CITY OF ALBUQUERQUE  
PLANNING DEPARTMENT  
DEVELOPMENT REVIEW BOARD

**Project# 1004913**  
13DRB-70456 MAJOR - 2YR SUBDIVISION IMPROVEMENTS AGREEMENT  
EXTENSION (2YR SIA)

HIGH MESA CONSULTING GROUP agent(s) for THE UNIVERSITY OF NEW MEXICO request(s) the referenced/ above action(s) for all or a portion of Tract(s) C, UNM LANDS WEST zoned C-3, located on CAMINO DE SALUD NE between I-25 and UNIVERSITY BLVD NE containing approximately 3.1657 acre(s). (J-15)

SCALE: 1" = 20'

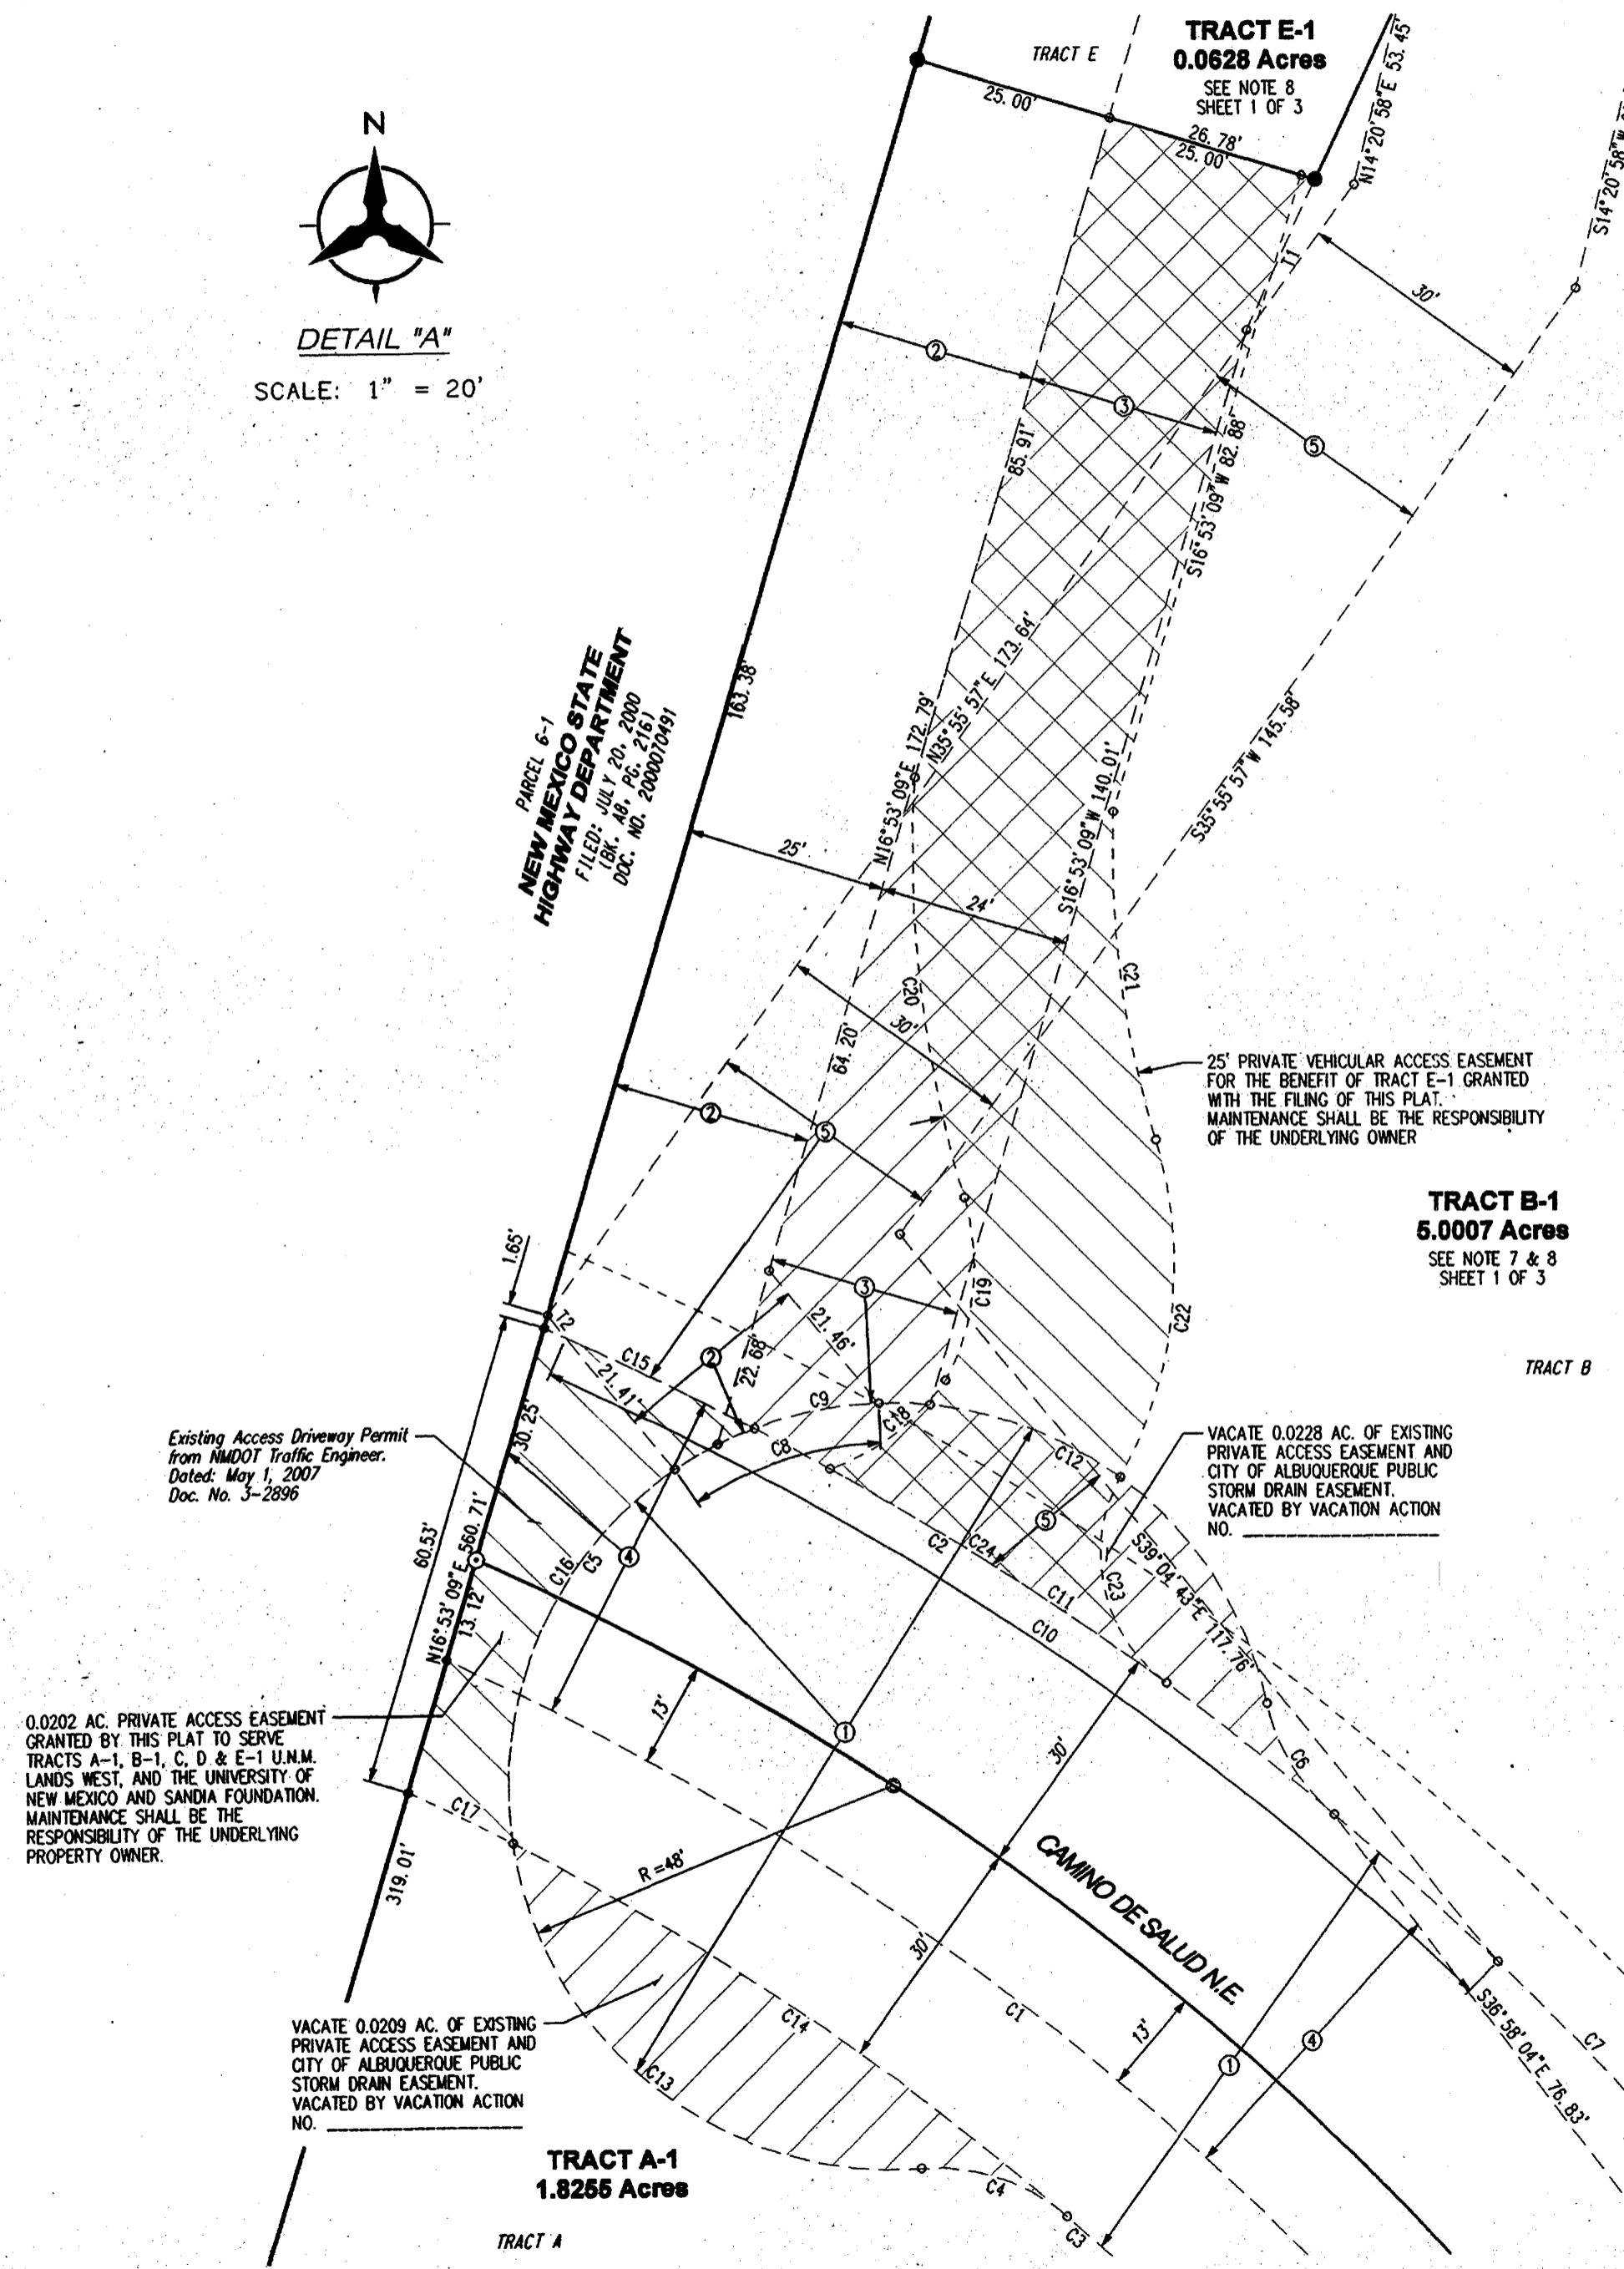
The beneficiary of an easement should be noted as a certain tract of land, not an owner, so that the easement rights run with the land. If the intent is to allow use of the easement(s) on this plat by the unplatted lands to the south and east, some type of legal description (e.g. 'Portions of Tract Z, K, & 5' etc.) should be used rather than ownership.
